SECTION 4.55(1A) APPLICATION TO AMEND SSD_9343 – MEADOWBANK SCHOOL

This letter has been prepared on behalf of NSW Department of Education (DoE) and School Infrastructure NSW (**the Proponent**) in support of a Section 4.55(1A) application to modify SSD_9343 in relation to Meadowbank Education and Employment Precinct Schools Project, at 2 Rhodes Street, Meadowbank (Lot 10 123584).

Sheet number MSP-WB-AR-DA201	Revision 11
Status PRELIMINARY

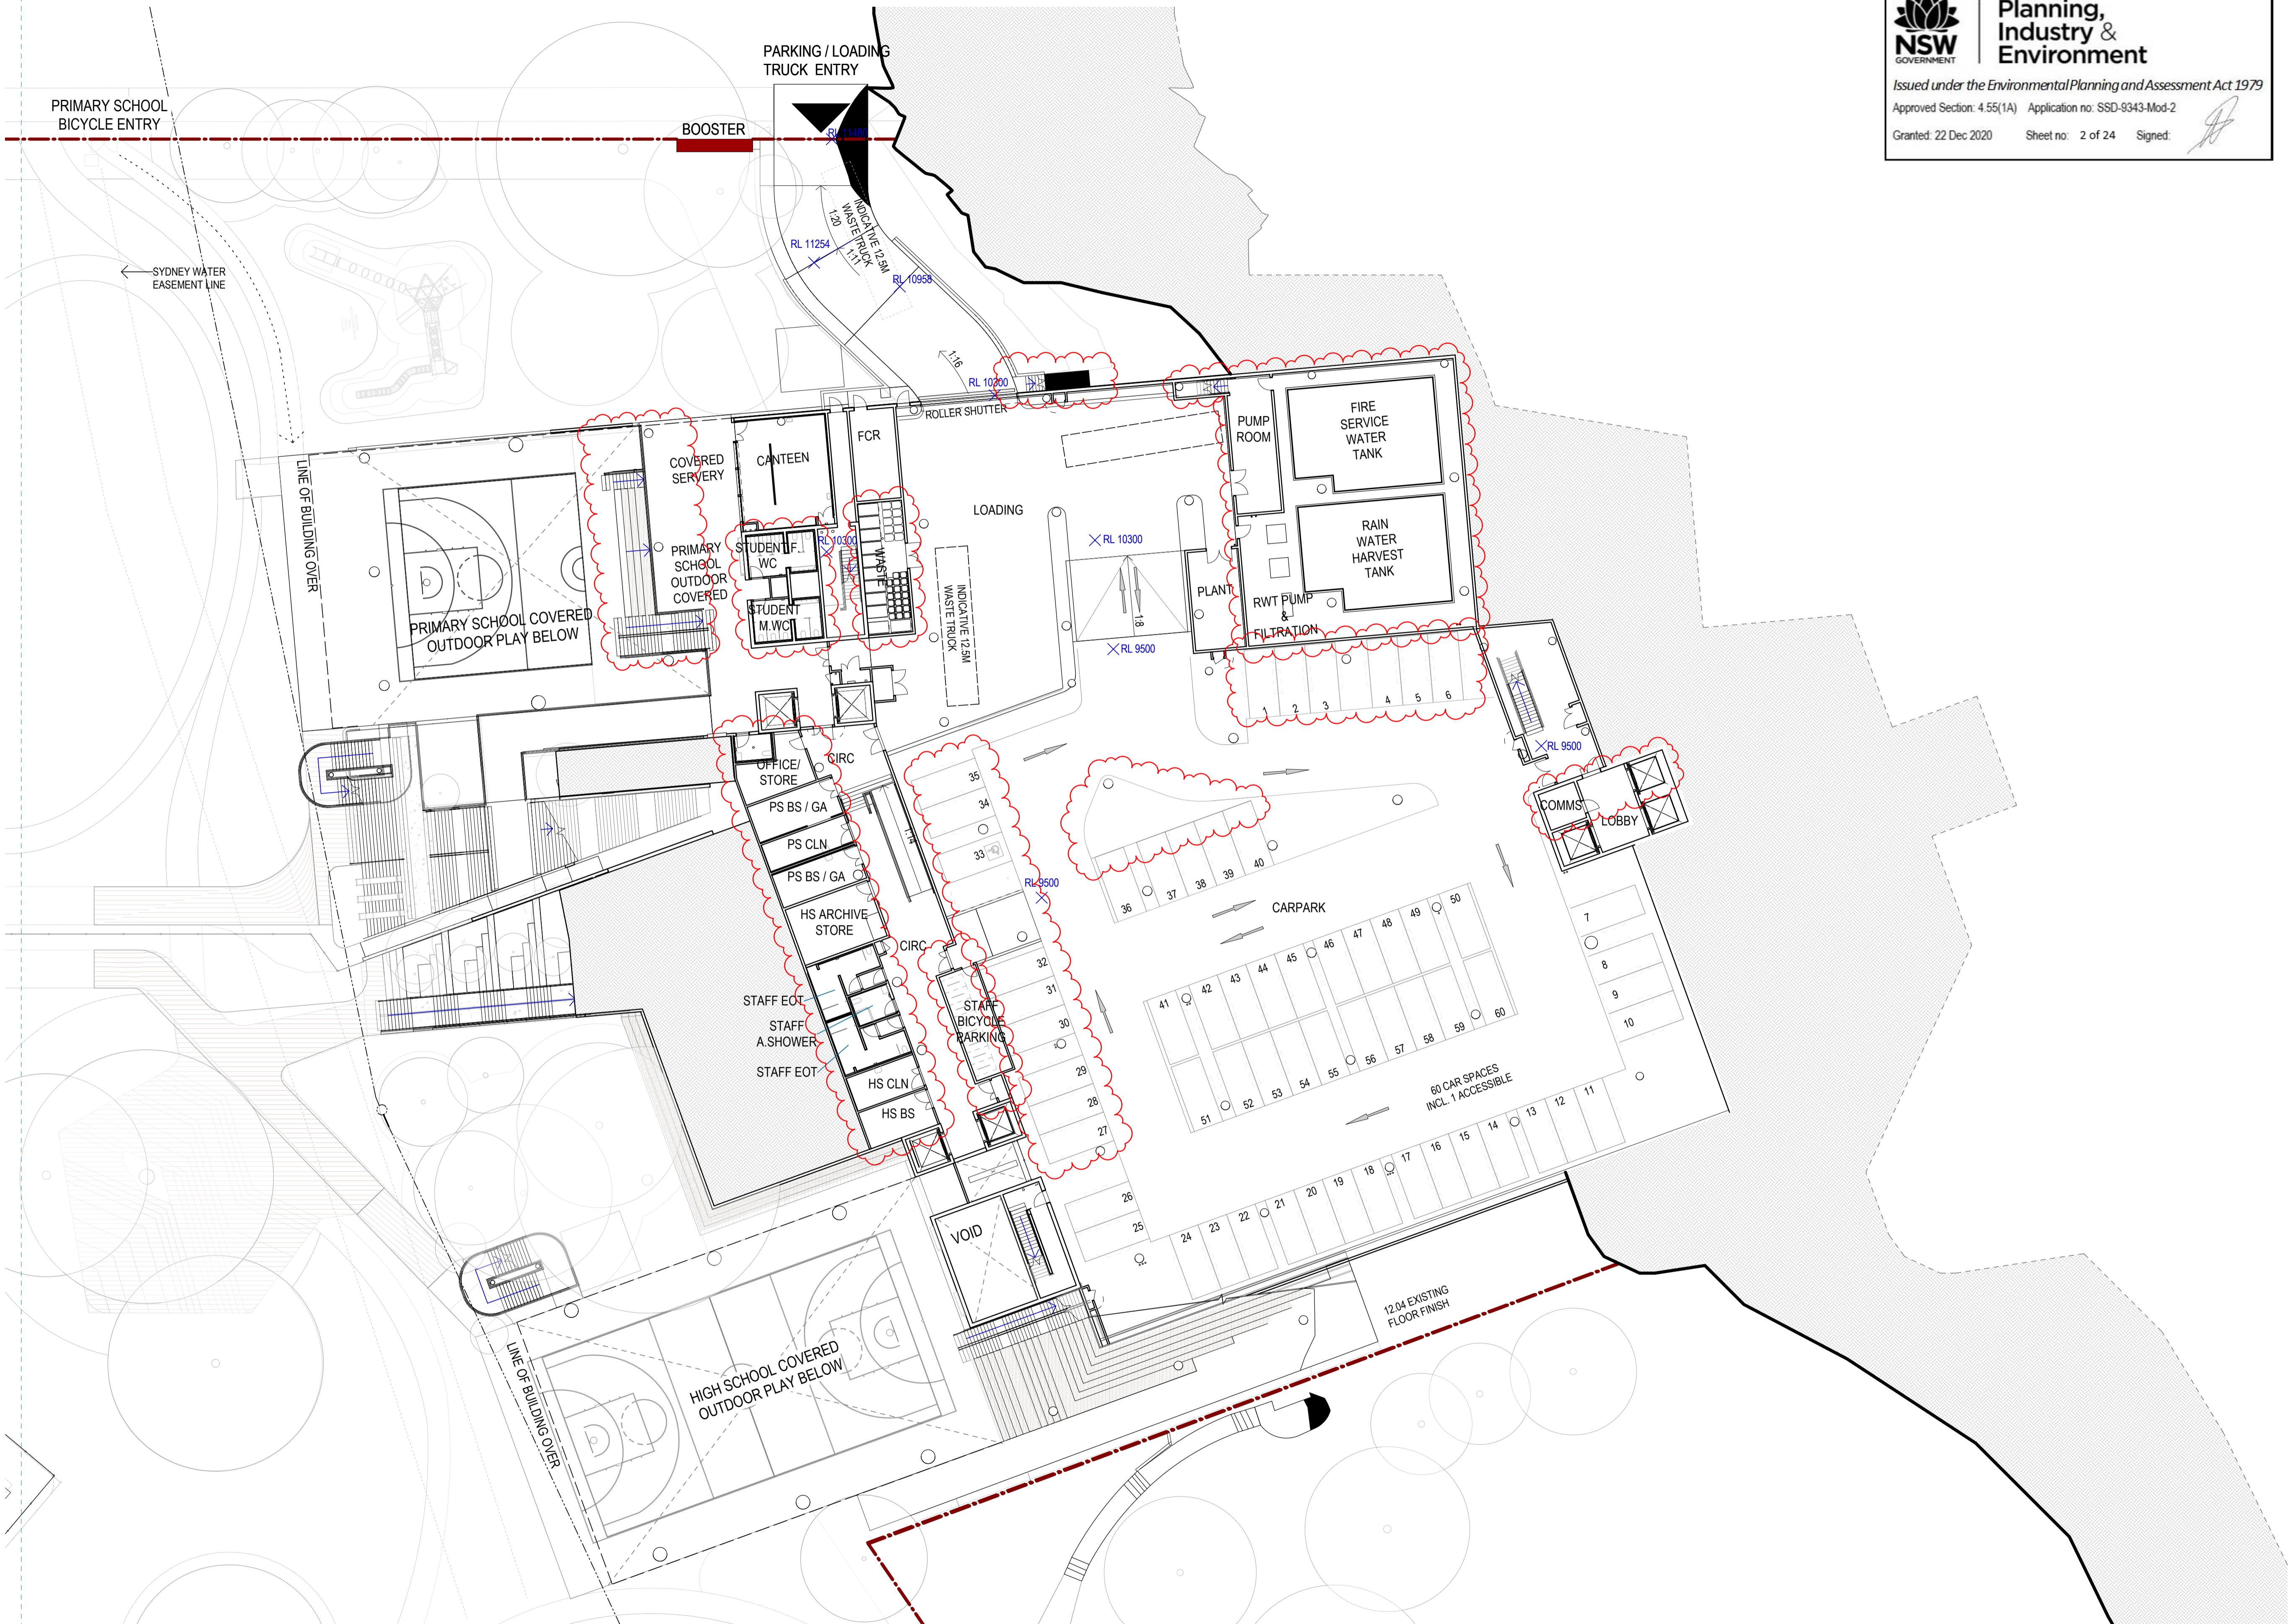
- Stairs and bleachers amended to allow larger area for canteen queuing.
- Amendments to toilet layout.
- Waste storage amended to be contained within one room.
- Fire and rainwater steel tanks located within same room.
- Car parking and bike parking layout including lift lobby access amended.

GROUND FLOOR PLAN

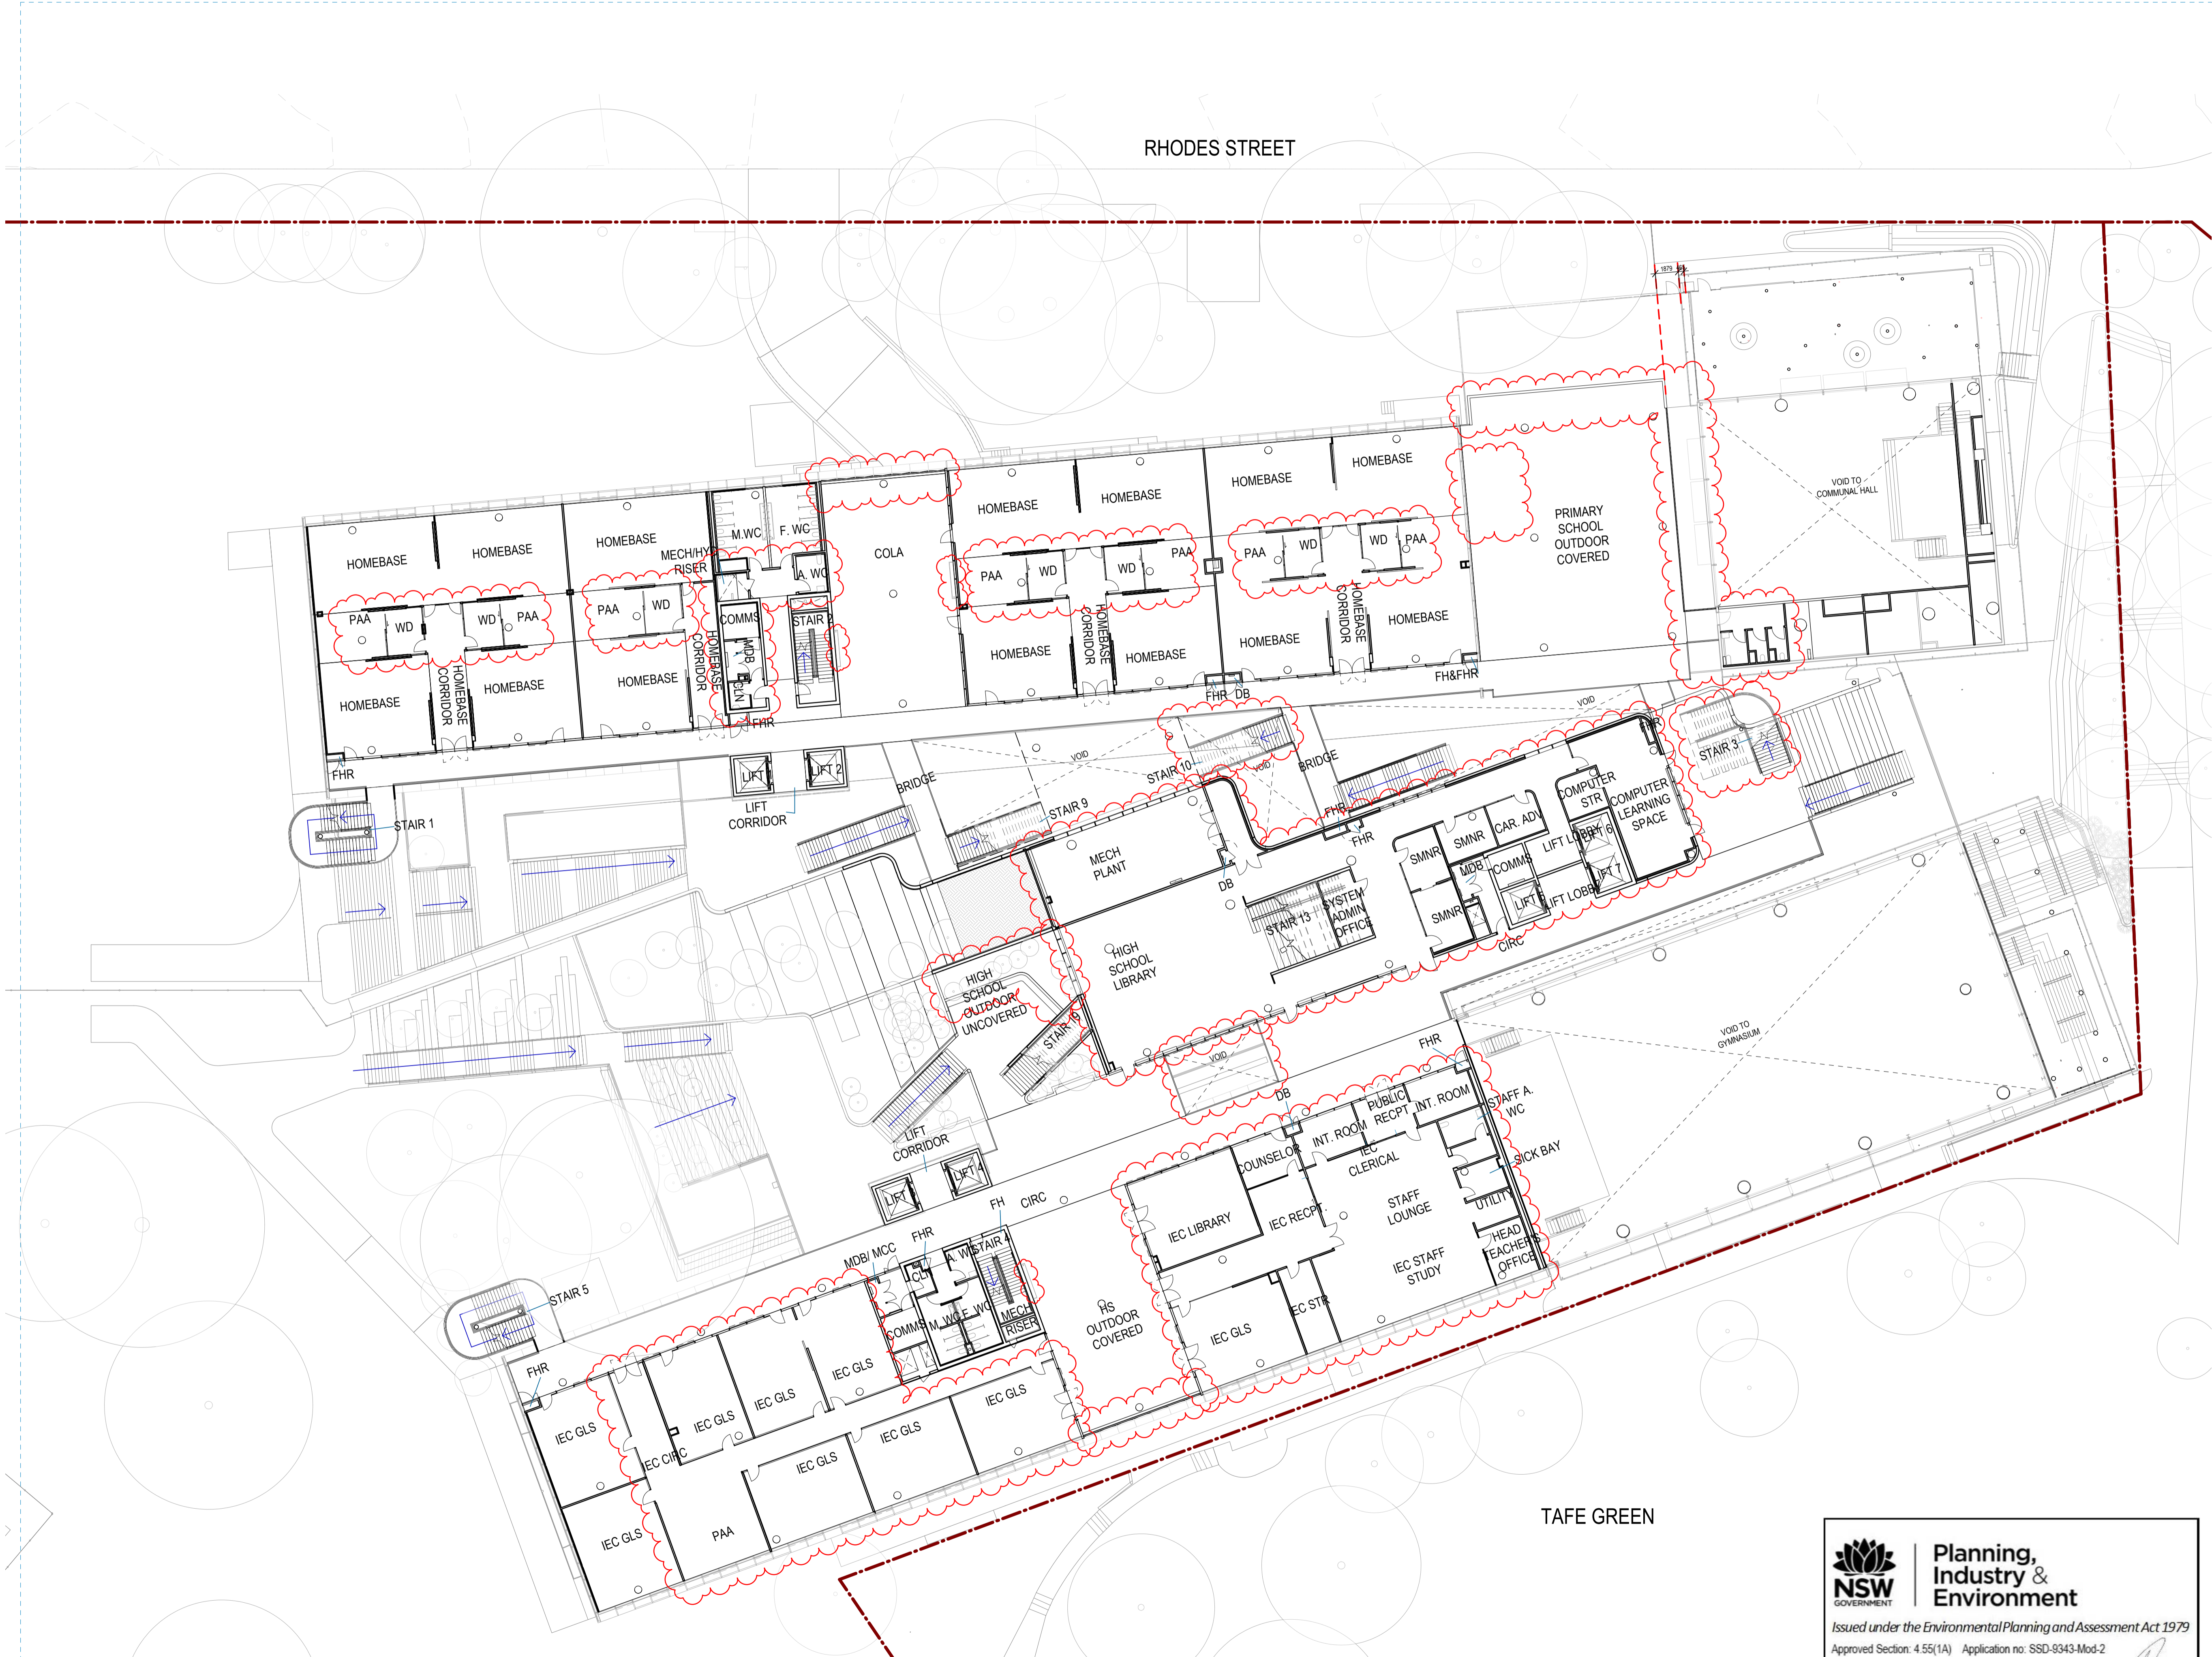
- Planters removed to all Covered Outdoor Learning Areas (COLA) façade edges.
- Full height balustrade added to COLA on both sides for student safety.
- Primary School fence simplified and design change to primary school entrance from Rhodes Street.
- Landscaping to High School entry.
- Void added to High School corridor.
- Landscape modifications, including:

- Additional paths, reconfiguration of stairs and amended to planting extent
- Location of trees amended with no reduction
- Steps, tactile and handrails added.
- Additional planting to replace removed planting

LEVEL 2 FLOOR PLAN

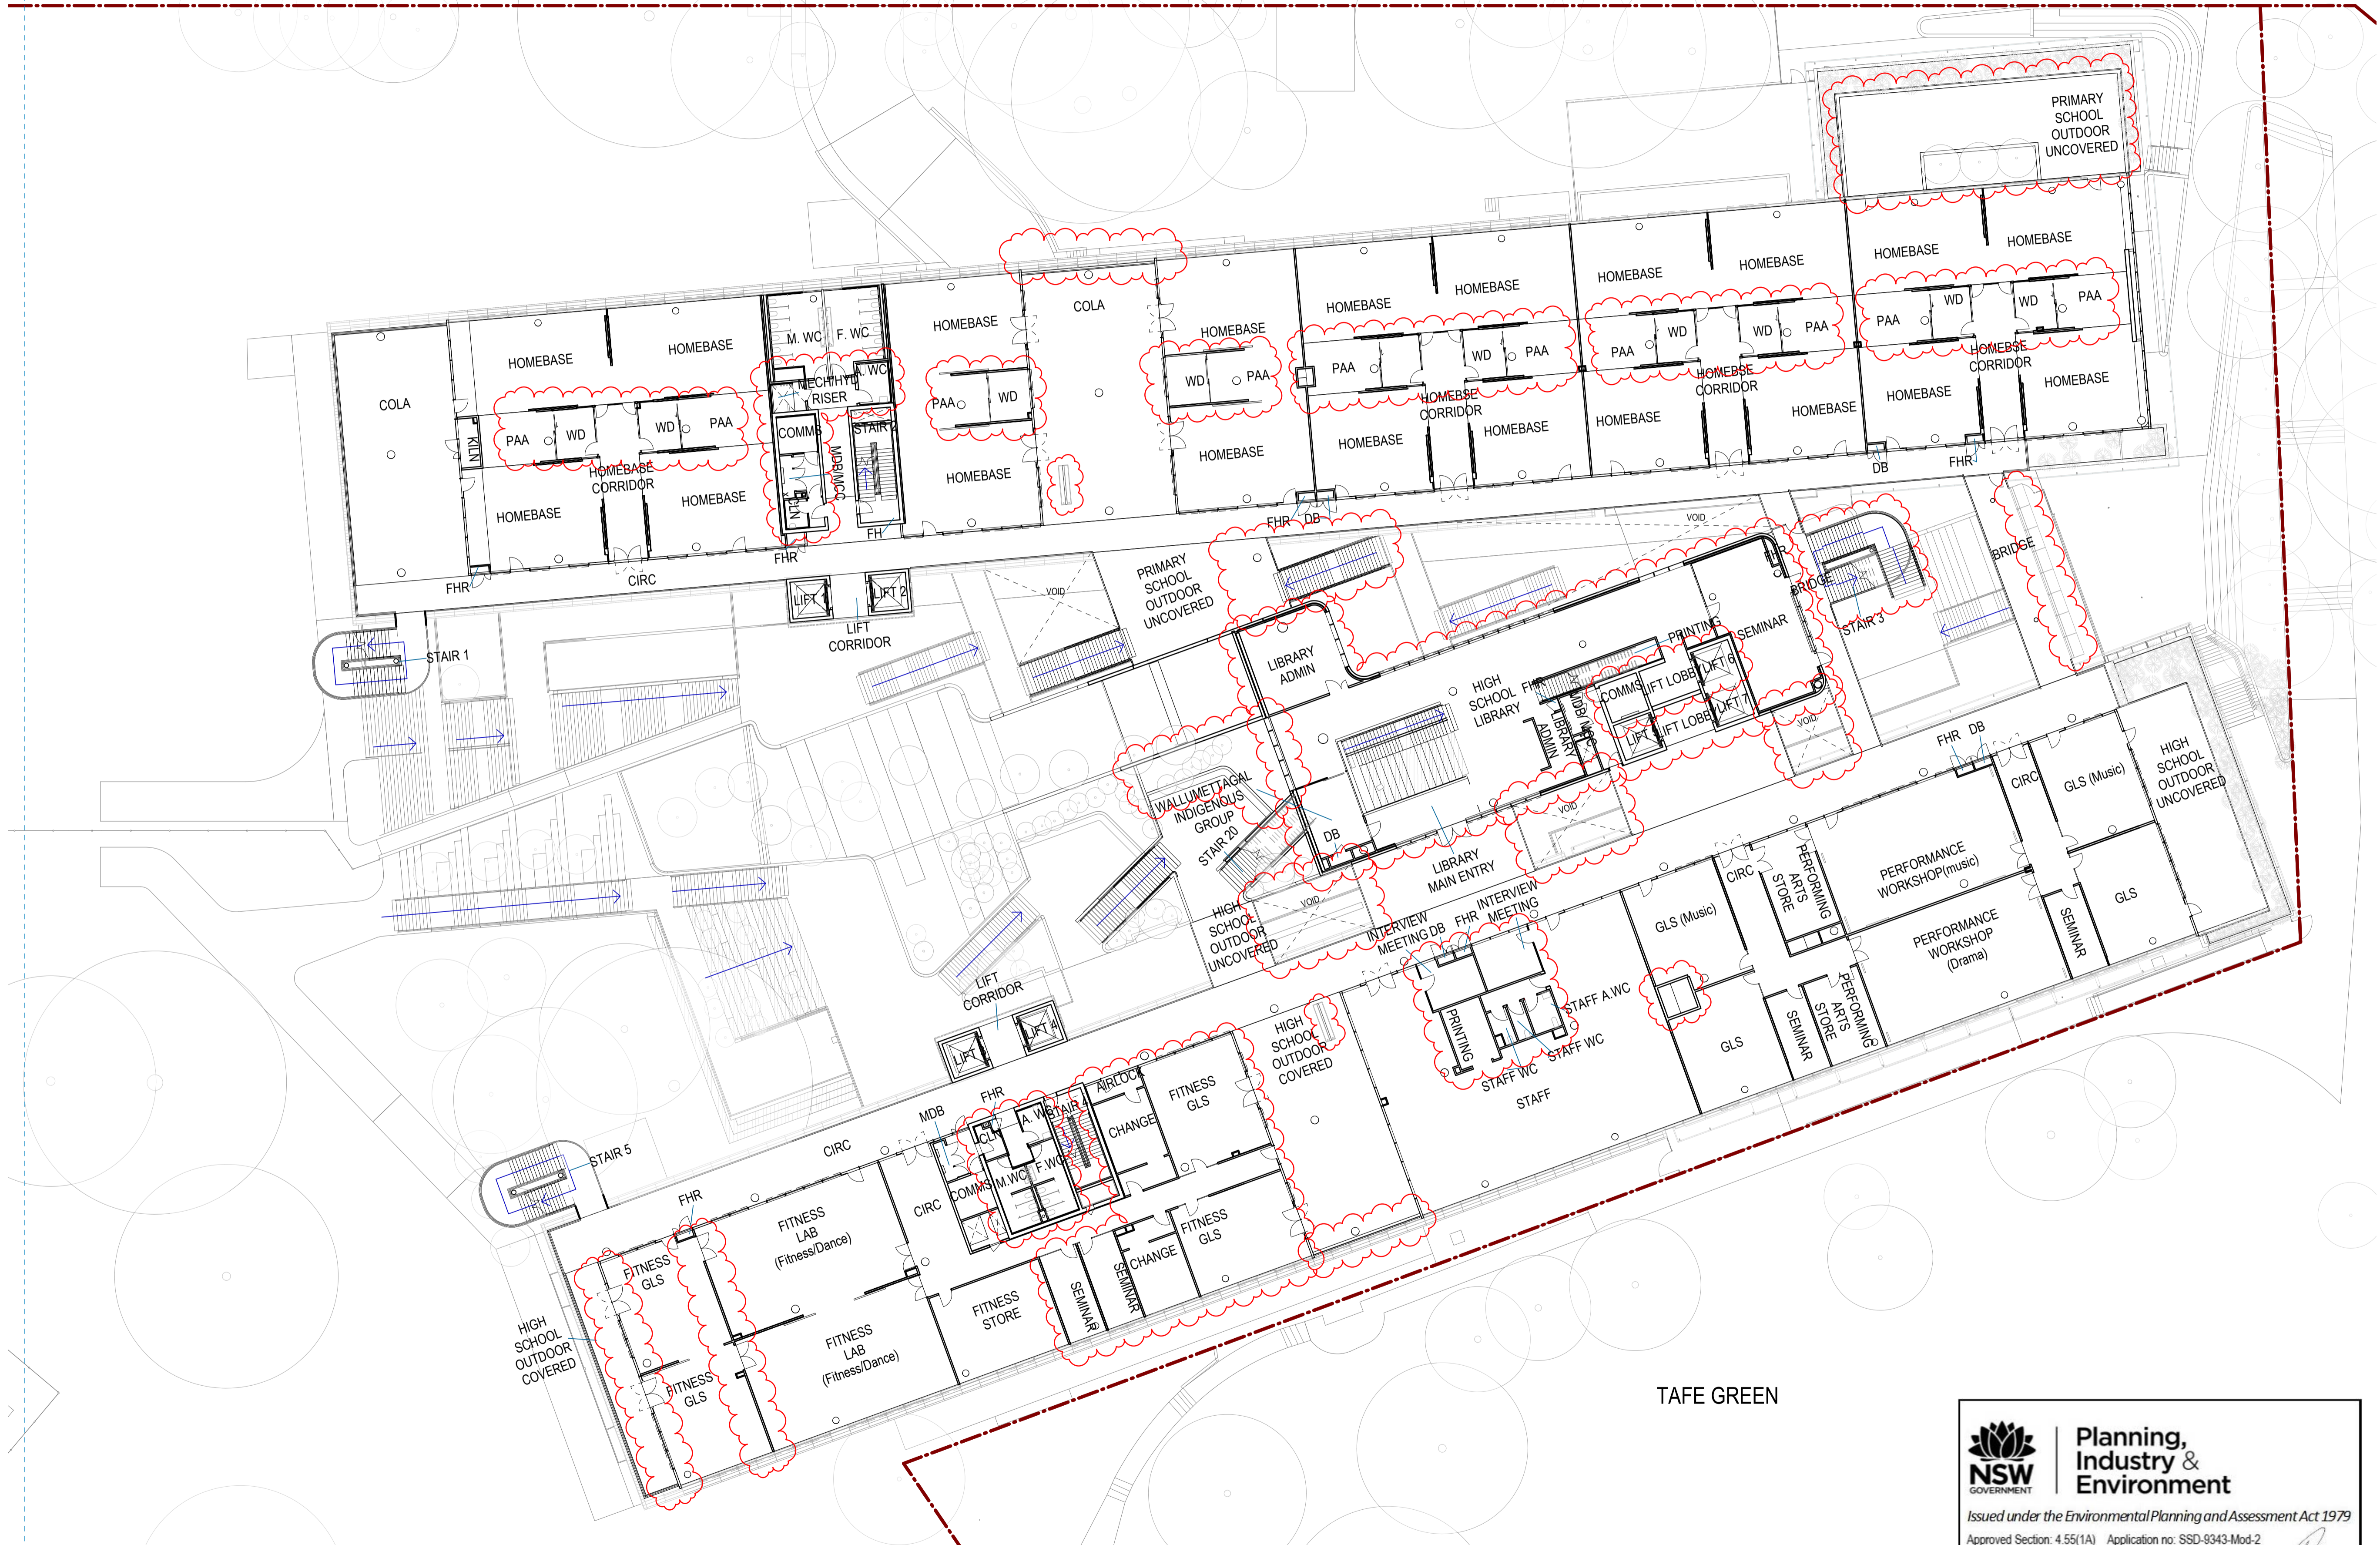
- Planters removed to all COLA façade edges of primary school and high school.
- Planter extent amended.
- Three void light wells removed from terrace of primary school outdoor uncovered area.
- Amendments and additions of voids.
